NSW RURAL FIRE SERVICE

Your Ref: MP 06_0250 MOD11
Our Ref: D18/7750
DA181024415724 AB

Agency Comment: MP06_0250 Mod 11 Seaside Village Estate Fern Bay

DRAWING TITLE SITE & STAGING PLAN REV-A
DEVELOPMENT PROJECT PLAN A FERN BAY SEASIDE VILLAGE NELSON BAY ROAD, FERN BAY
CLIENT ASPEN GROUP LIMITED

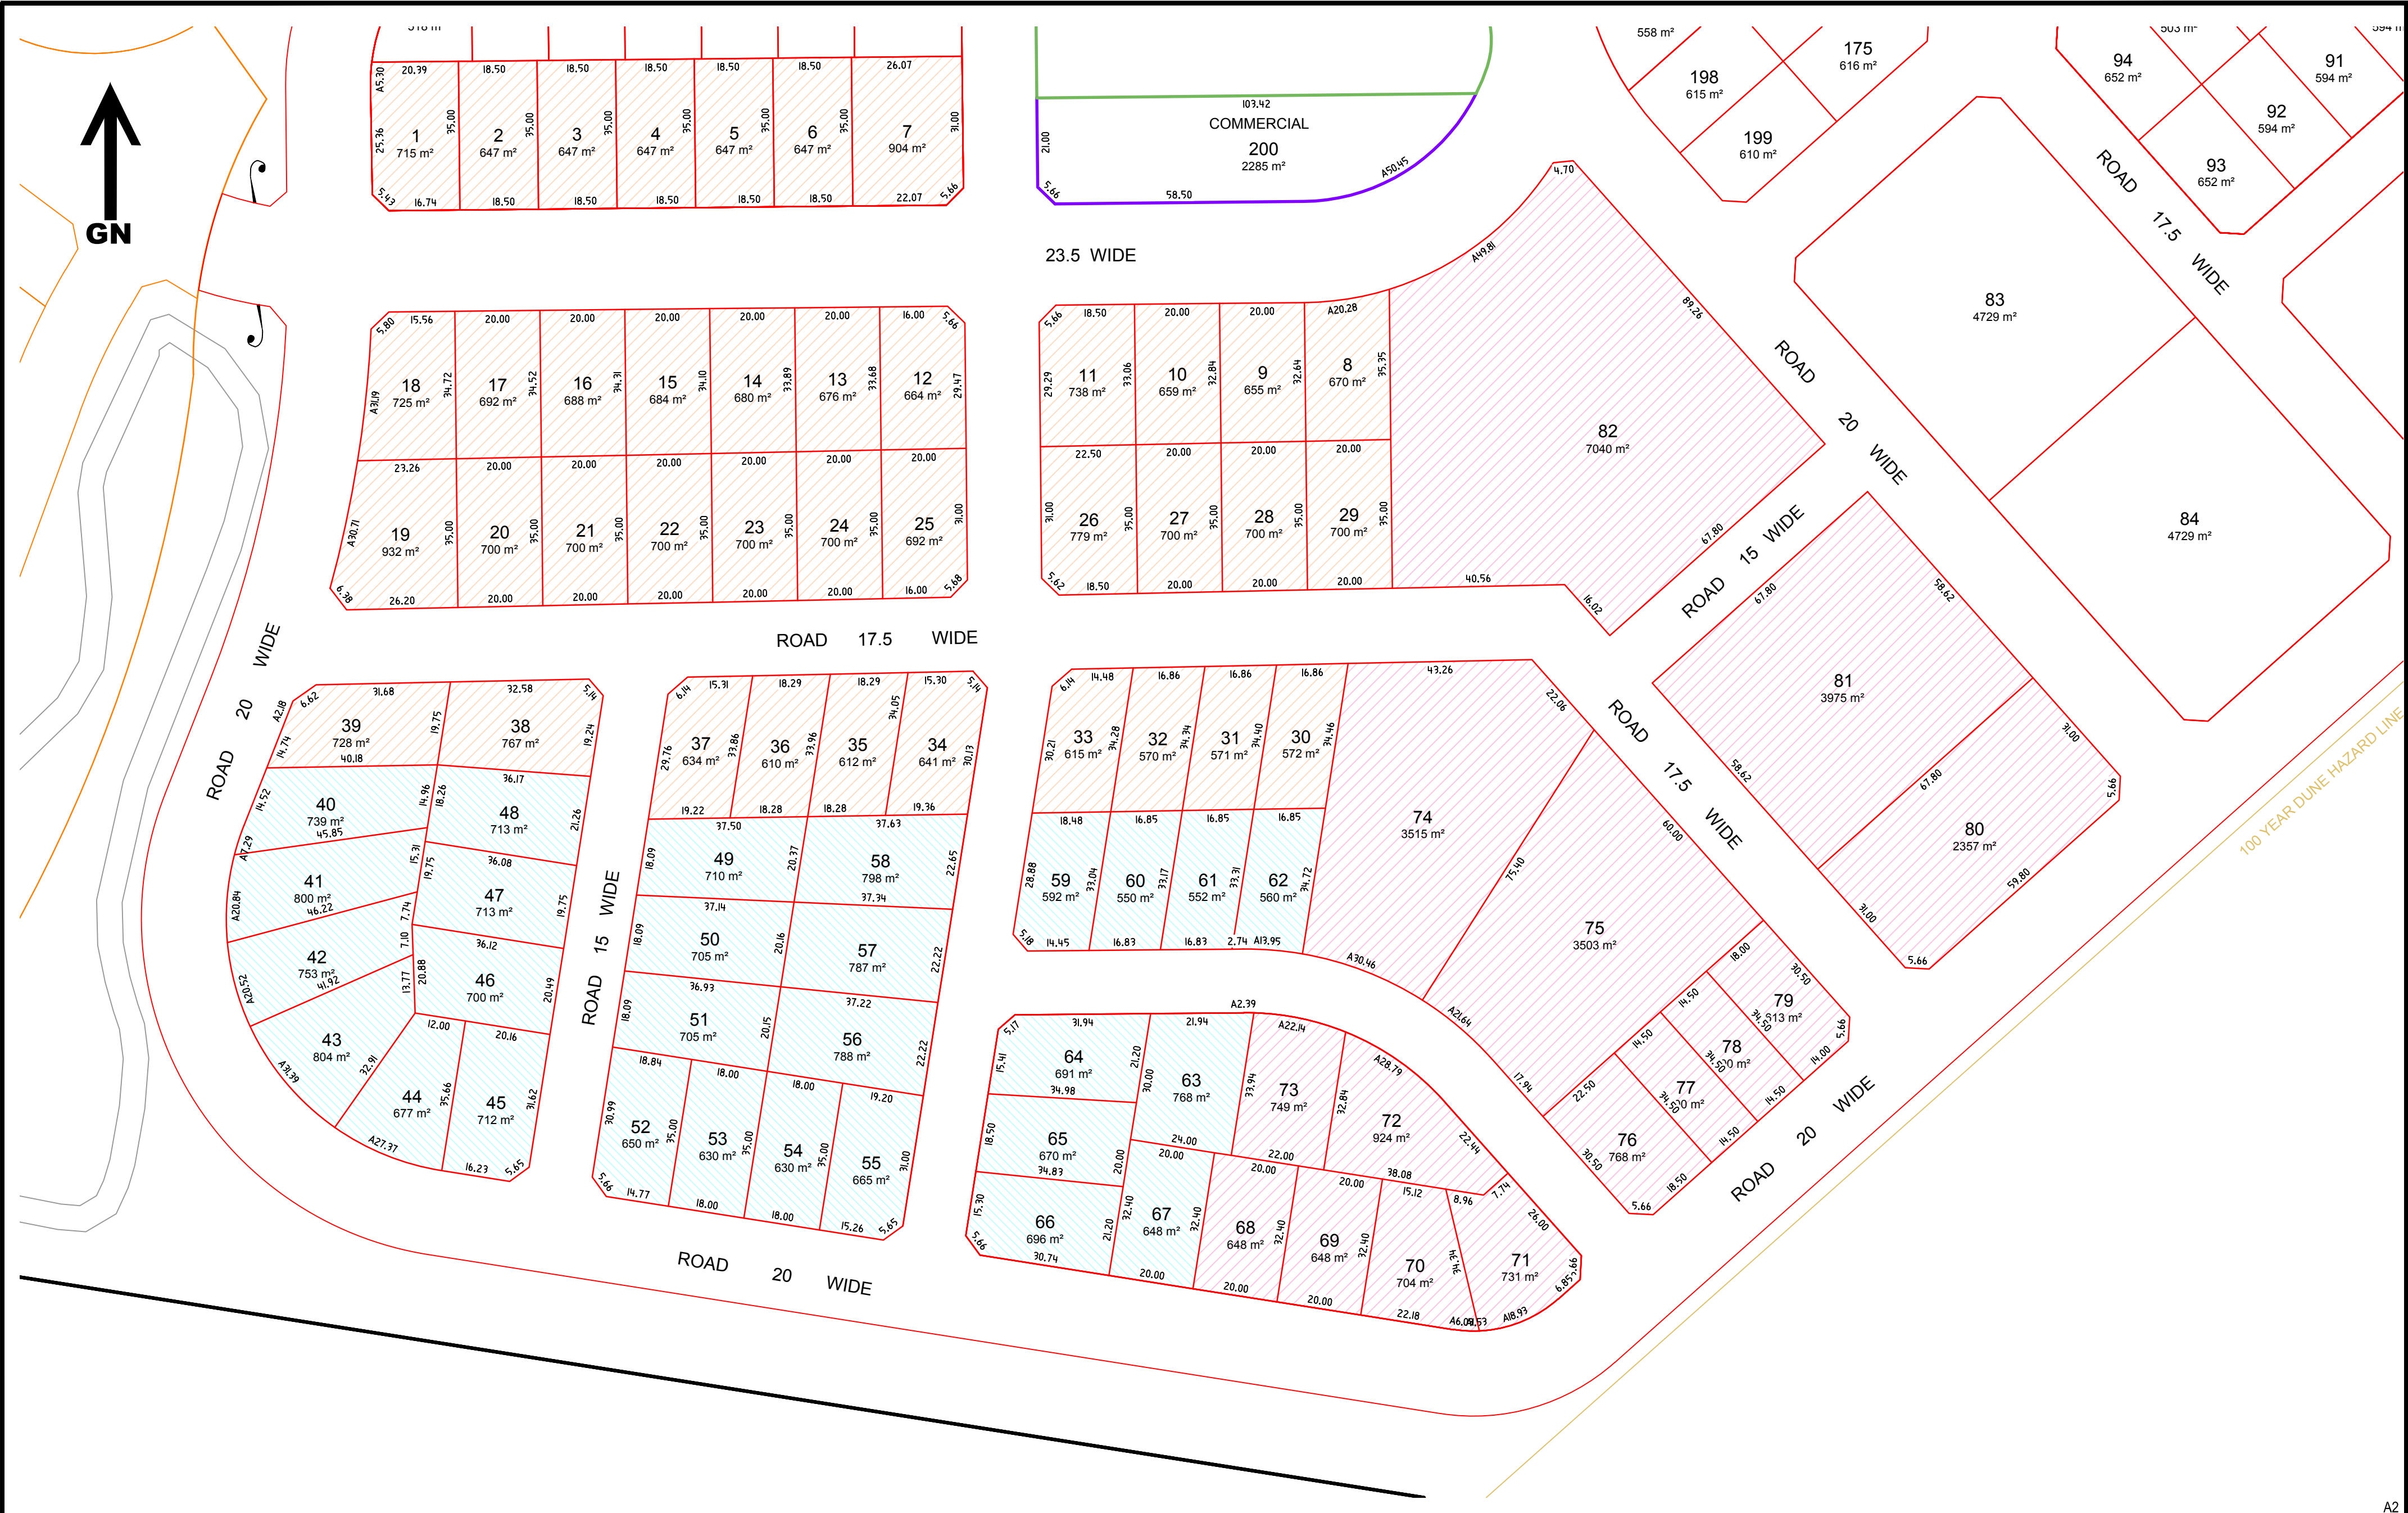
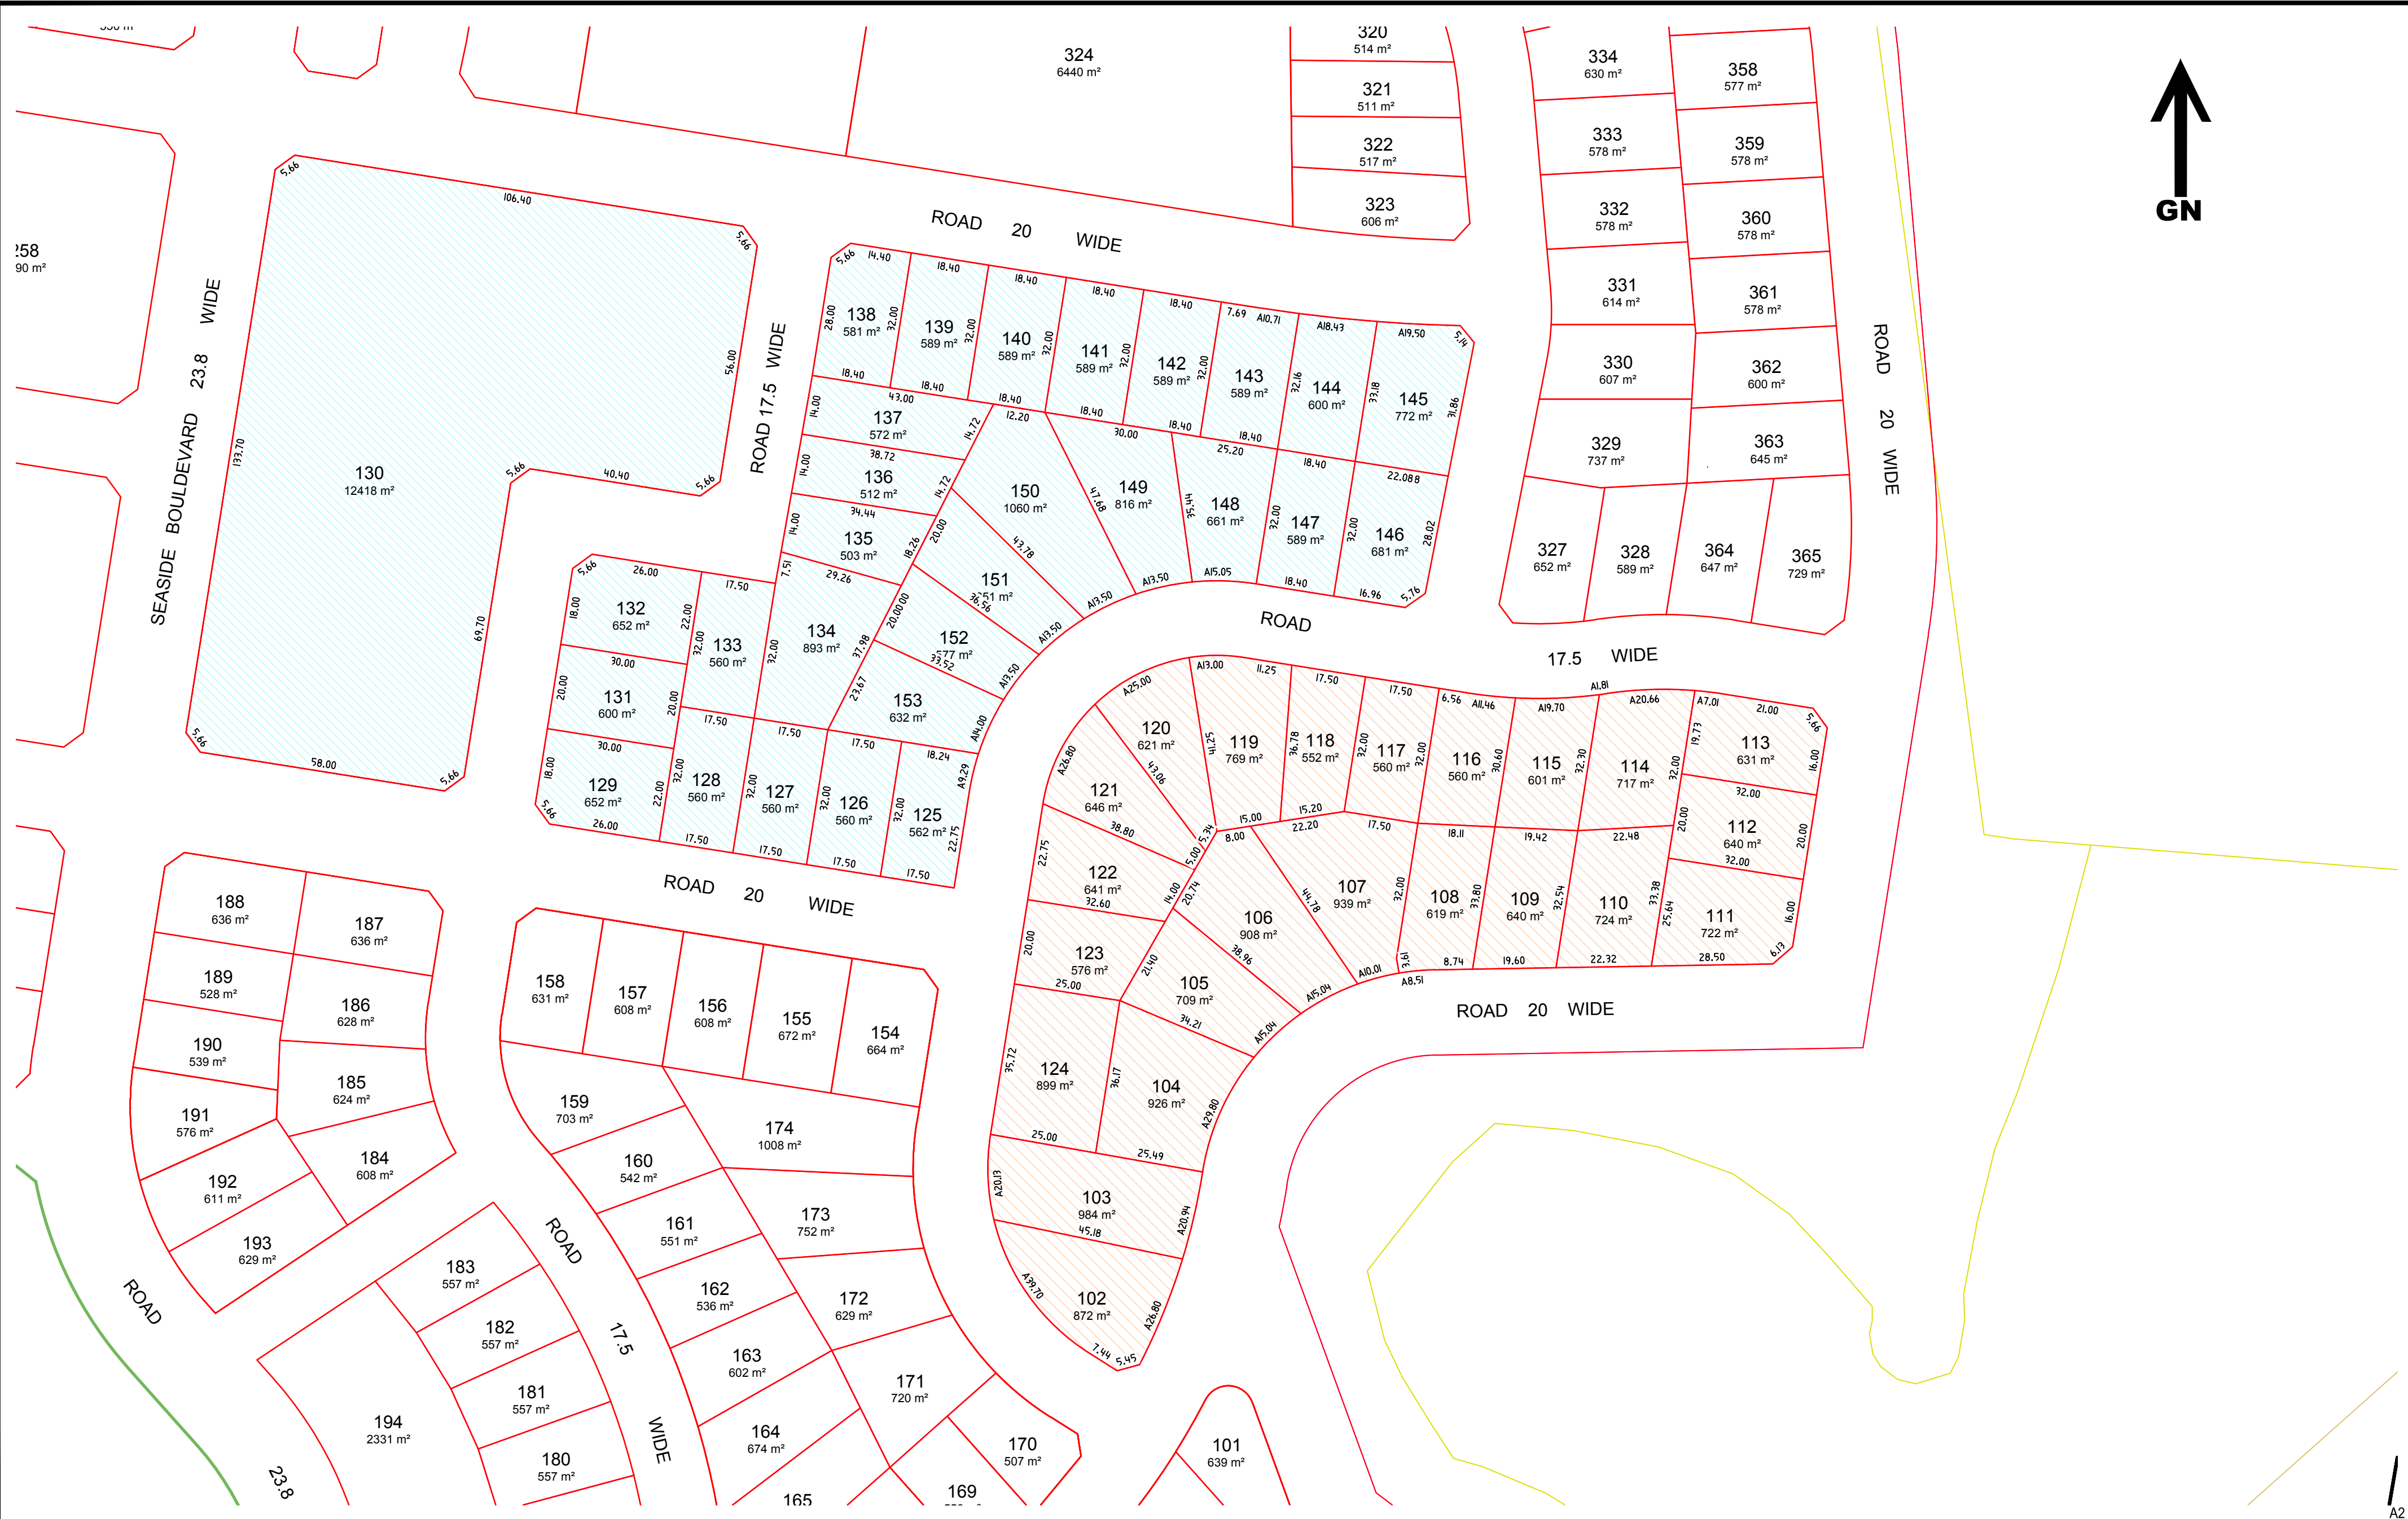
1. The application has not provided sufficient justification for deferring the construction of the Seaside Boulevard/Nelson Bay Road intersection till after the subdivision release of stage 14.
Stage 14 residential release was the trigger for the Seaside Boulevard roadworks including the completion of the intersection works. This was to ensure a secondary

The NSW RFS is of the opinion that the proposed intersection is critical to public access/egress in a bush fire emergency. Delays caused by design works and approvals processes are not considered sufficient justification for deferment of these works.

2. Until such time as the intersection works have been completed, the developer should maintain an emergency vehicle access arrangement at the current junction of Seaside Boulevard and Nelson Bay Road.
